# CITY OF PORTLAND, MAINE

## PLANNING BOARD

March 17, 2015

**Project Name:** Midtown  
**Project ID:** #2014-203  
**Address:** 59 Somerset Street  
**CBL:** 34-B-2, 3, 4, 5, 22 and 34-D-3, 9, 10  
**Applicant:** FEDEQ DV001, LLC.  
**Planner:** Richard Knowland

**TYPICAL CROSS SECTION
ALONG "PINCH POINT" BEHIND midtown Two (High)**
SCALE: 1" = 4' Horiz., 1" = 8' Vert.

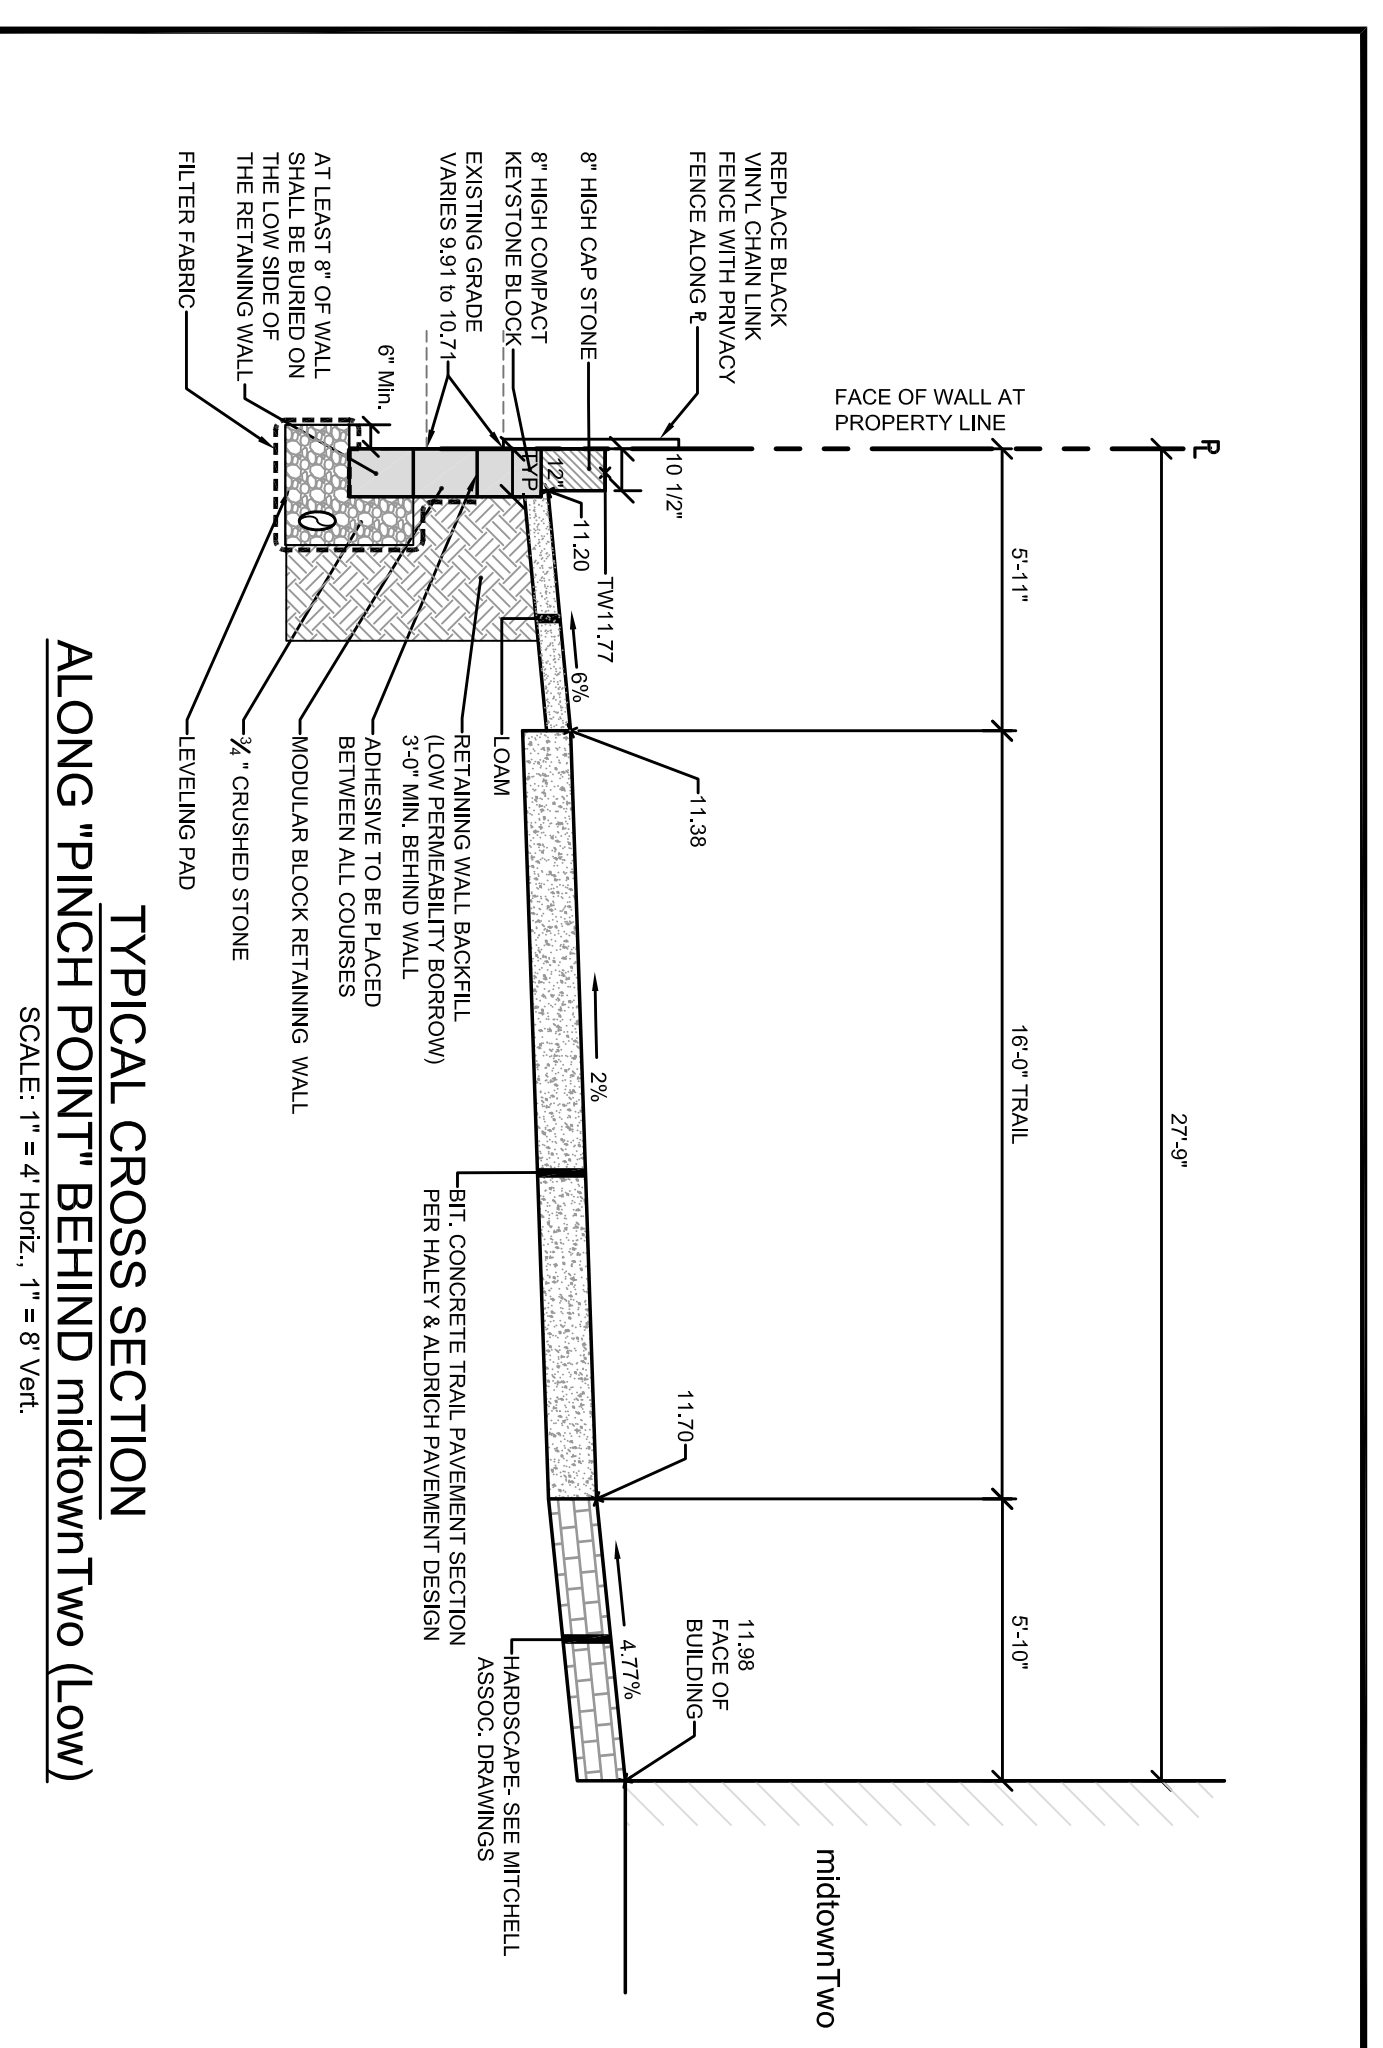
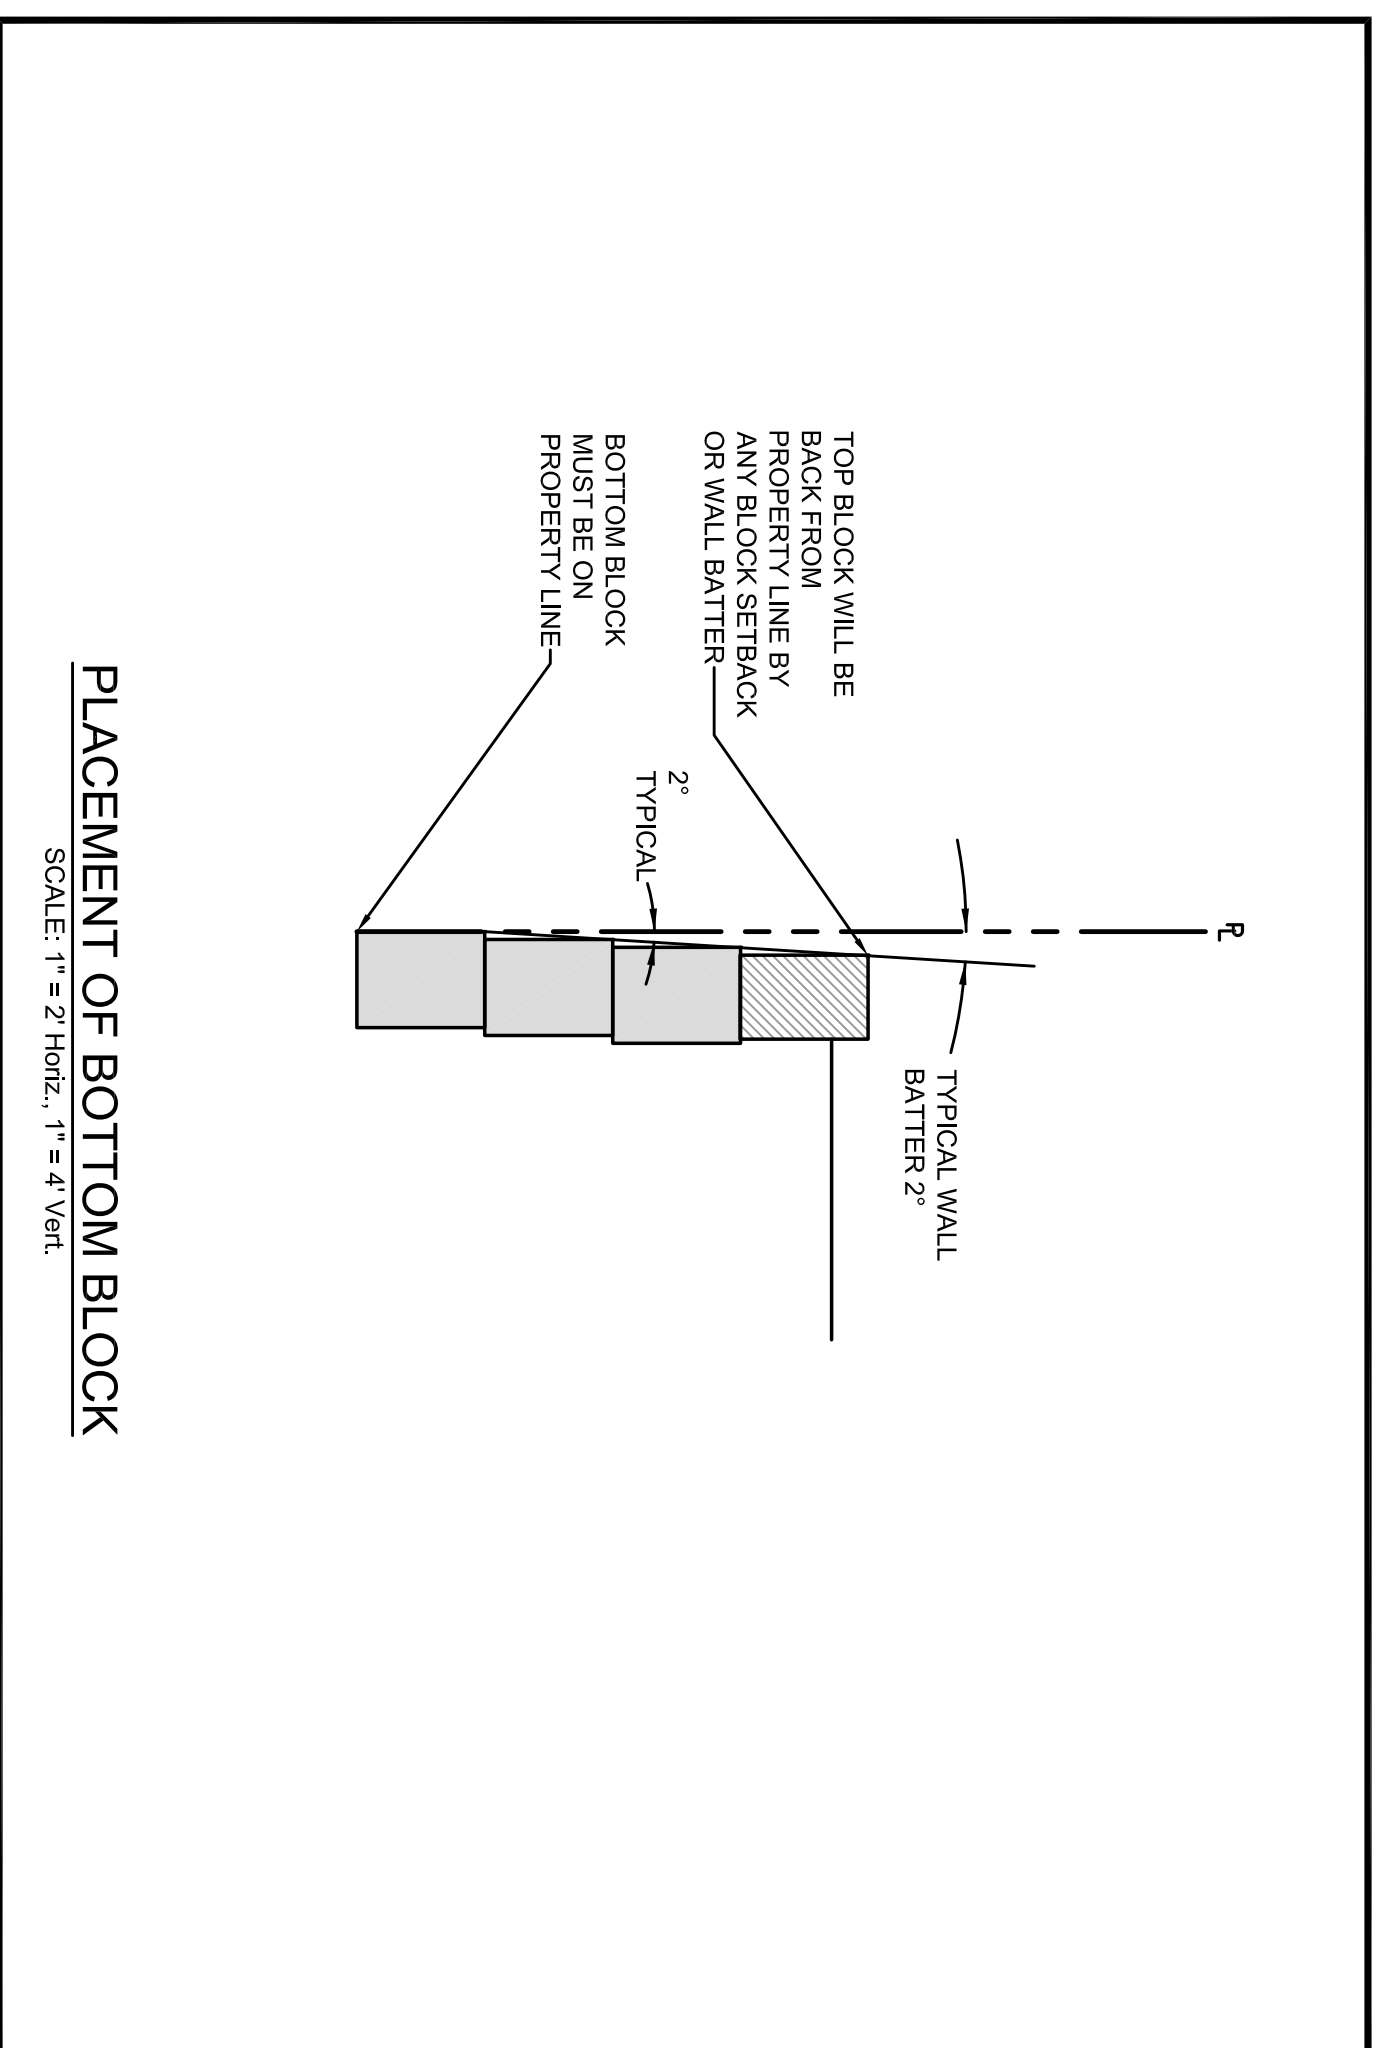
12. For the areas behind midtown One and midtown Two, from Bayside Trail STA 6+50 to STA 12+50 (refer to sheets C-3.0 and C-7.12), the face of the retaining wall and fence are proposed primarily on the property line between City of Portland (Bayside Trail) property and the parcels located north of the Bayside Trail. Temporary construction agreements shall be obtained by the Applicant from the adjacent property owner(s) to complete the work as proposed.
